Lower Thames Crossing

5.4.1.6 Draft Agreed Statement of Common Ground between (1) National Highways and (2) Natural England (Clean version)

Planning Inspectorate Scheme Ref: TR010032
Application Document Ref: TR010032/APP/5.4.1.6

VERSION: 5.0

*Local Landscape Character Area boundaries of the Kent Downs AONB LCA, West Kent Downs, Sub-areas Cobham and Shorne*

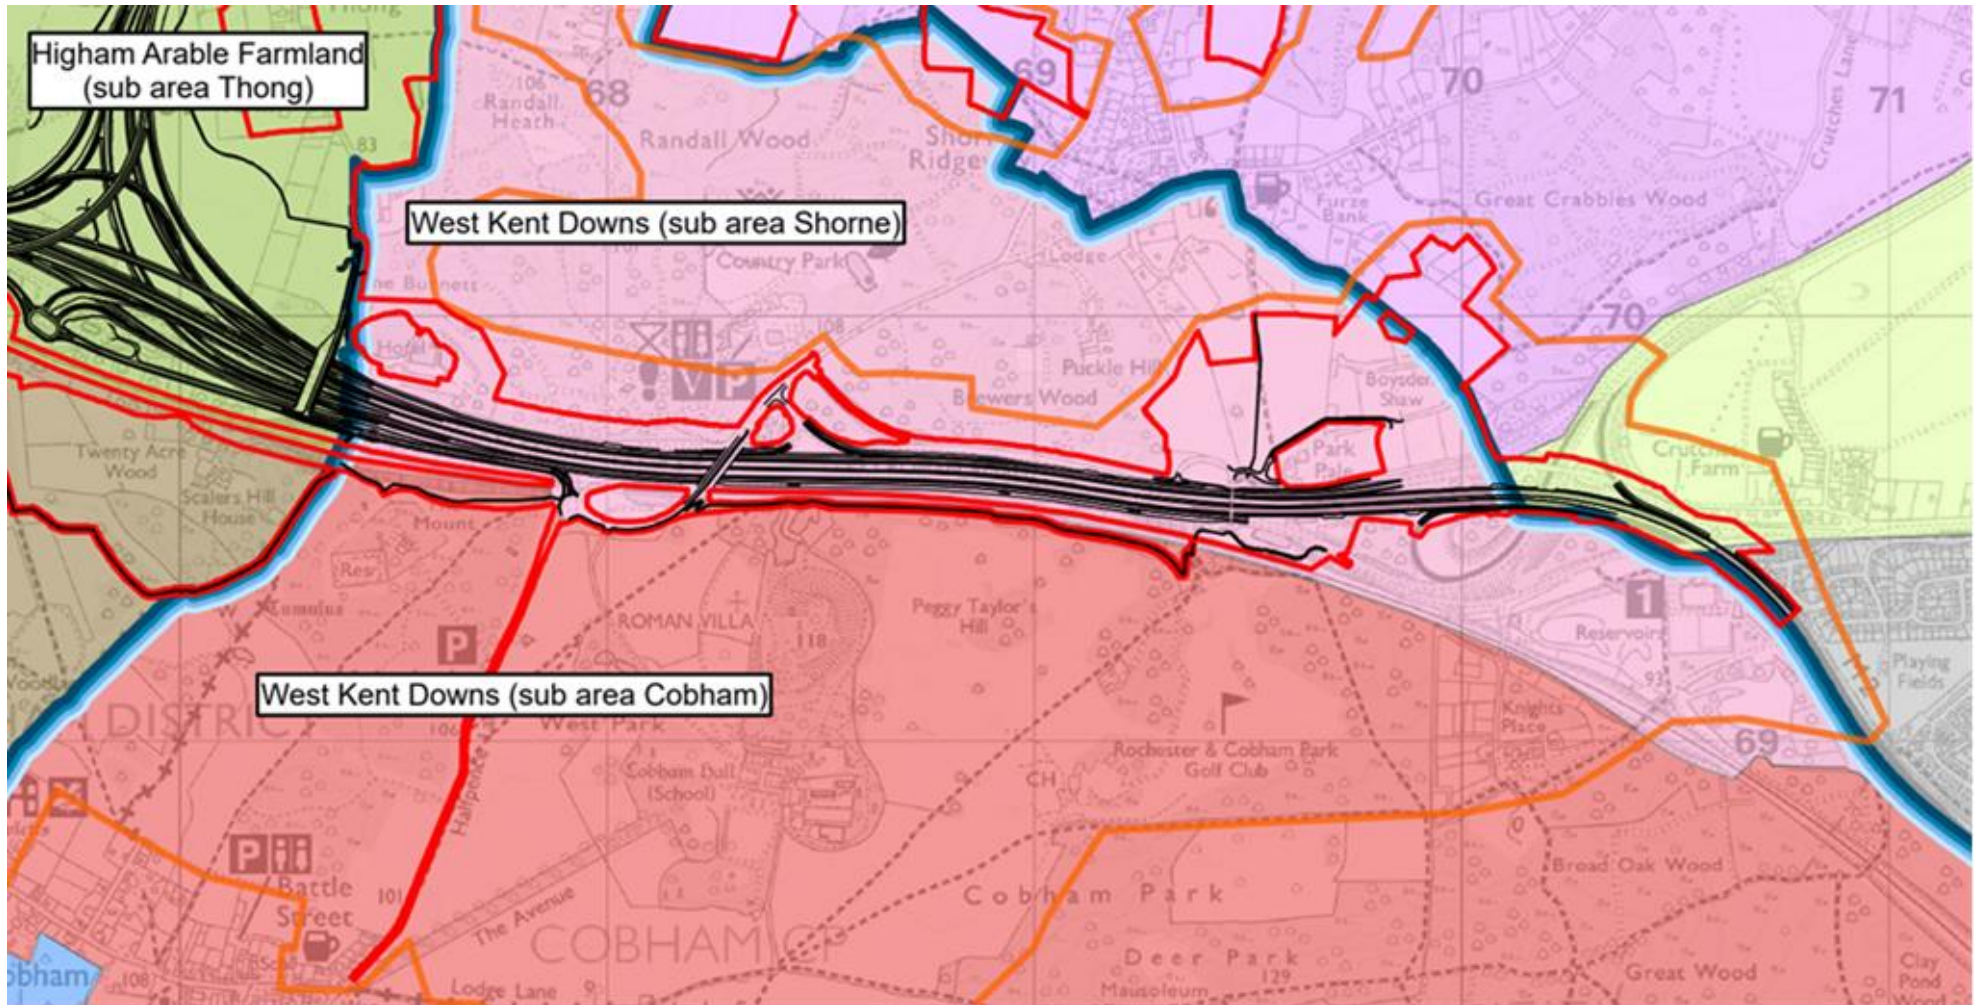
Visual					
Baseline	2.1.105 WR (DL5)	The Environmental Statement appears to show incorrect boundaries for the contiguous West Kent Downs (sub area Cobham) and West Kent Downs (sub area Shorne) Local Landscape Character Areas (LLCA). The Cobham sub area boundary largely follows the northern boundary of the existing A2/High Speed 1 Rail Line alignment whereas the Environmental Statement shows the same Character Area boundary running to the south of the A2/High Speed 1 Rail Line. The	The boundaries of the LLCAs within the Kent Downs AONB have not been incorrectly transposed. As detailed in Appendix A of Comments on Written Representations, the boundaries of character areas identified in the studies have been used to inform the definition of the LLCAs, which have been used as a basis for the assessment of effects on the landscape at the local level. In a limited number of locations, the boundaries of the published character areas have been slightly adjusted	ES Chapter 7: Landscape and Visual [APP-145] Comments on Written Representations Appendix A- Statutory Environmental Bodies [REP2-046]	Matter Not Agreed

Topic	Item No.	Natural England Comment	The Applicant's Response	Application Document Reference	Status
		incorrect transposition of the boundaries for these two sub-Character Areas is likely to mean that the assessment of landscape and visual effects within the Environmental Statement are incorrect.	through detailed study and analysis undertaken for the LVIA. Notwithstanding this slight difference in the West Kent Downs (sub area Cobham) LLCA boundary, the effects of the Project are fully assessed either as direct or indirect effects within the West Kent Downs (sub area Cobham) LLCA and/or the neighbouring West Kent Downs (sub area Shorne) LLCA. The findings of these two assessments are then brought together into a combined assessment for the overarching West Kent Downs Landscape Character Area (LCA) 1A. The combined effects reported in the landscape impact summary Tables 7.33 and 7.34 in Section 7.9 of ES Chapter 7: Landscape and Visual, and the overall conclusion of the landscape and visual impact assessment would therefore not differ if the Cobham and Shorne sub area boundary is drawn in a different location.	Natural England's Written Representation paragraphs 6.1.3, 6.1.4 and 6.1.7 [REP1-262]
